Access Assessment Report

72-74 Maitland Street, Muswellbrook – Stage 1

Reference No: 111917-Access-r04

Date: 20 September 2021

Drawing Reference Revision
 19055-NBRS-DR-A-SSDA-2000 15

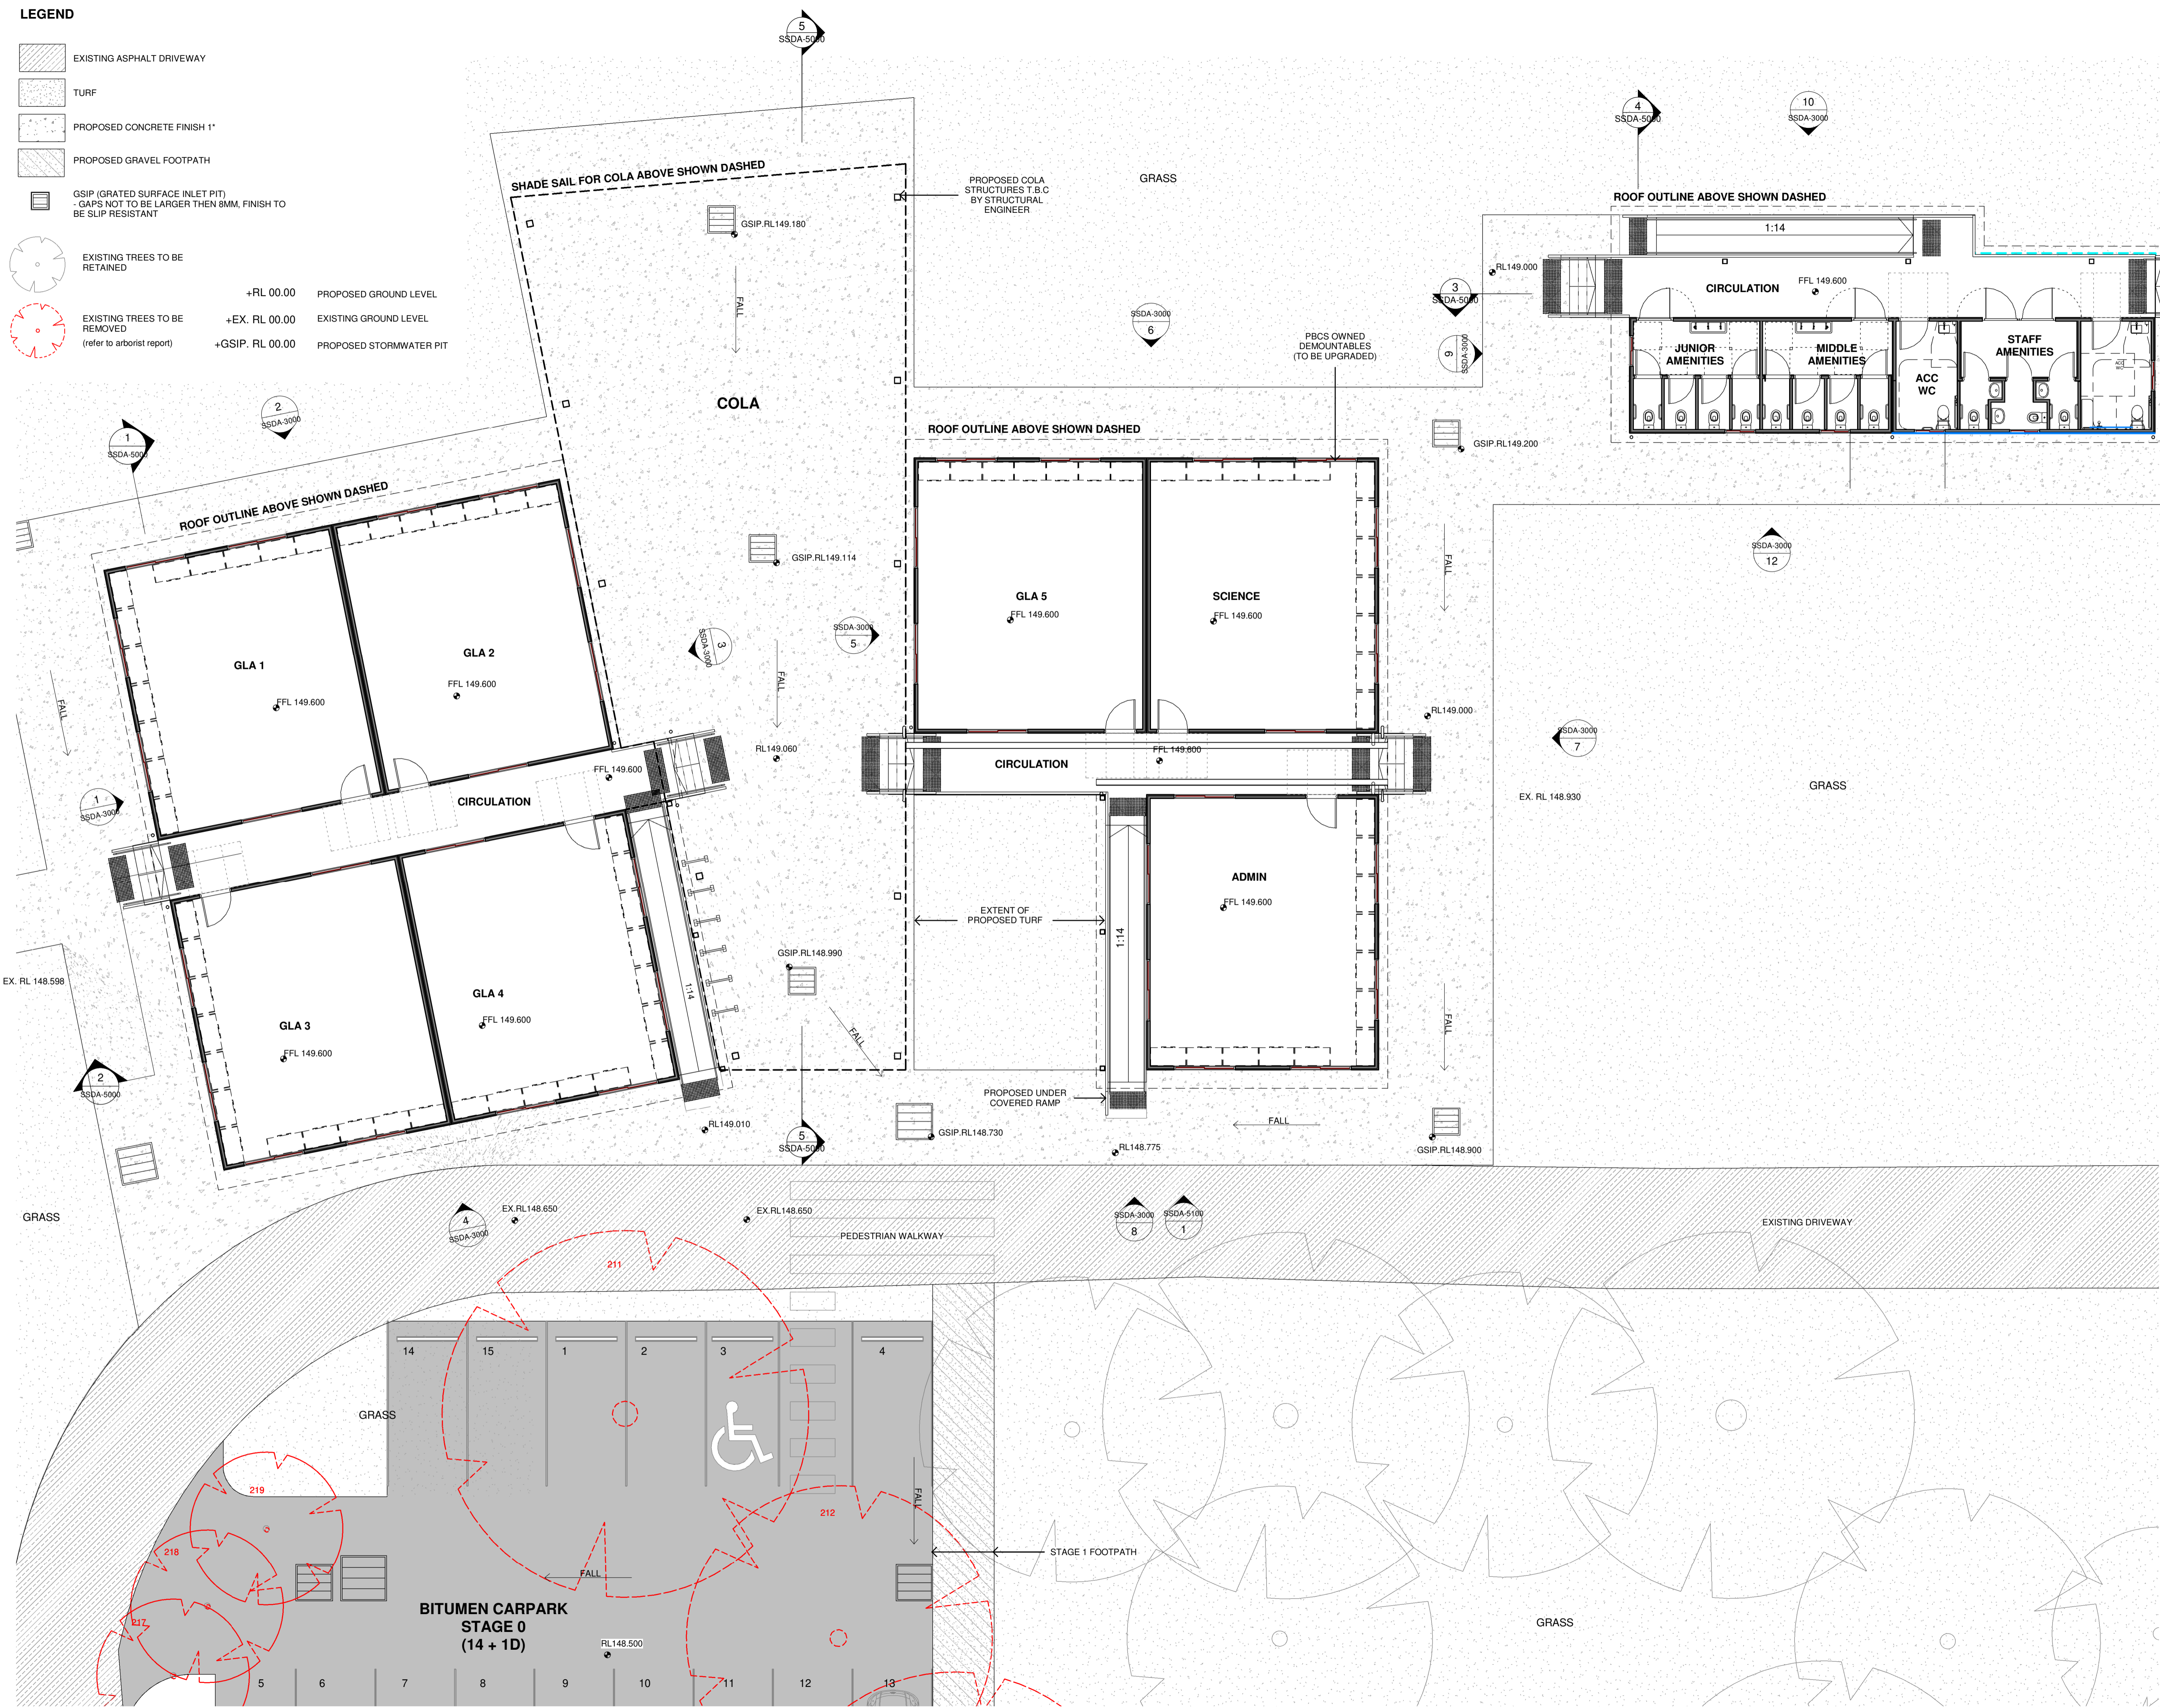
Currently, the design will need to incorporate kerb rails along each handrail where the handrail does not terminate at the top of the ramp, but rather continues along the remainder of the deck space outside each classroom.

Currently, the handrail design of the stairs will need to include a 300mm continuation at the base of the stairs.

Initially Stage 1 works proposes a total of 13 carparking spaces as part of the development, of which one has been nominated as an accessible parking space. This sizing, provisions for a shared zone with a bollard, identification signage, and line markings are to comply with the requirements of AS2890.6 for

Currently two unisex accessible sanitary facilities are proposed for the amenities block. One of each is for allocation to staff and students. The construction of these facilities is to comply with Clause 15 of AS1428.1-2006. In addition, the proposed ambulant WC's for both staff and student are to comply with Clause 16 of AS1428.1-2009.
